July 25, 2022

Re: Quality Auto Center – *Tech Review 2*  
PA22005

RE: Quality Auto Center, File# PA22-005  
New Car Dealership  
15233 Smokey Point Blvd. & Parcel # 31053300205300

PRELIMINARY SITE PLAN

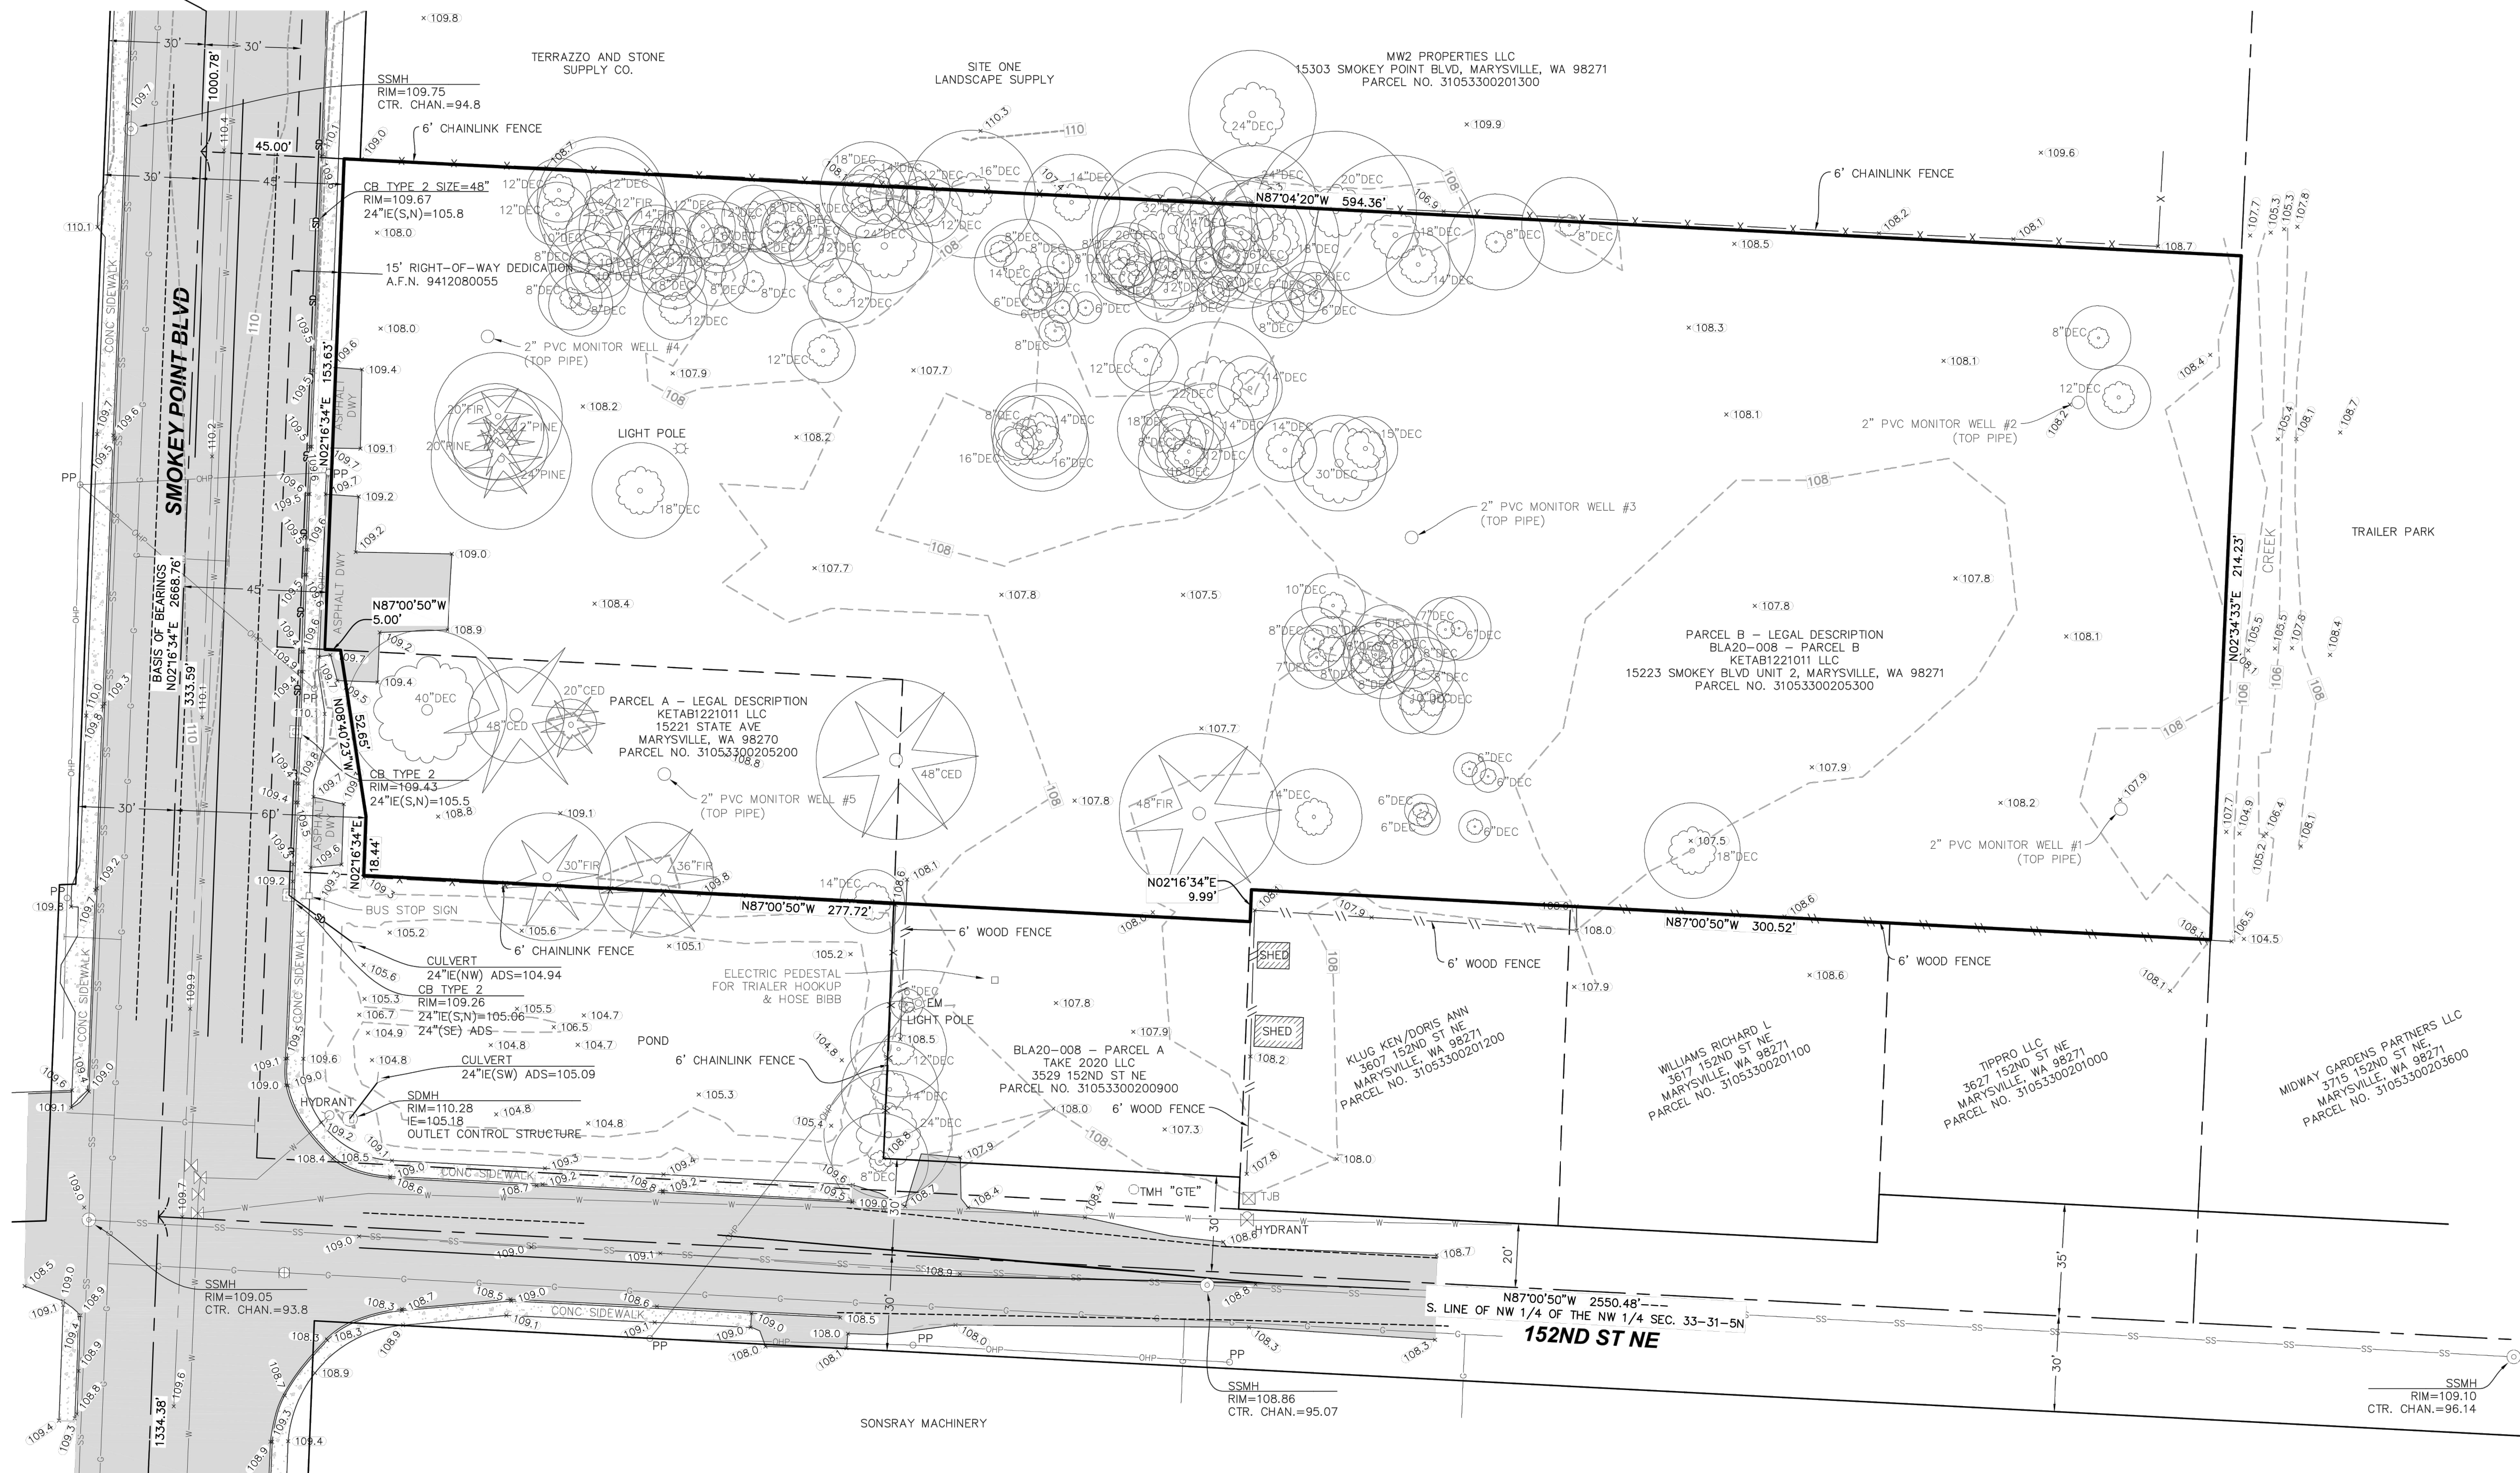
1. Sheet P1 shall be amended, as follows (see attached redlines):
  - a. **TR1 Comment:** The pedestrian connection shall be relocated to align with the front entry to the showroom to the sidewalk. Pursuant to [MMC 22C.130.050\(5\)\(c\)](#), the pedestrian pathway shall be constructed with decorative concrete and physically separated from vehicle traffic and maneuvering areas.

A minimum 5' landscape islands shall be provided on either side of the pedestrian pathway as it traverses through the proposed parking spaces and/or inventory lot.

**TR2 Comment:** As noted in MMC 22C.130.050(5)(c), developments **must** provide specially marked or paved walkways through parking lots, as depicted in Figures 1 through 4. Figures 1 through 4 clearly show landscaping within tree grates, which would require a larger width pathway, or landscape islands. The 5' landscape islands adjacent to the walkway referenced in the TR1 comments are required in accordance with MMC 22C.120.130(5)(b) & (c), based on the location of the required walkway.

Additionally, the walkway proposed is not physically separated from vehicle traffic and maneuvering areas and must be raised and constructed similar to a public sidewalk.

The TR1 comments still apply and the site plan shall be amended to meet these conditions.

**Applicant's Response:** Pedestrian connection cannot be made at midpoint of the property frontage and have the required fill material to provide separation from groundwater. The Elevations here do not work.

130.050(5)(c) requires that pedestrians and wheelchairs easily gain access from Public Streets. . .to building entrances through use of raised concrete or pervious pavement sidewalks. . ., **or** pedestrian paths which are physically separated from vehicle. . .

We are proposing the use of pervious pavement dyed brick red and not optioning for the "or" separated path.

We do provide landscape on the side of the walk as it crosses landscape areas and do not see in the code where the 5' landscape islands on either side of the path are required. *Five foot landscape islands are not including in MMC 22C.130.050(5)(c)*.
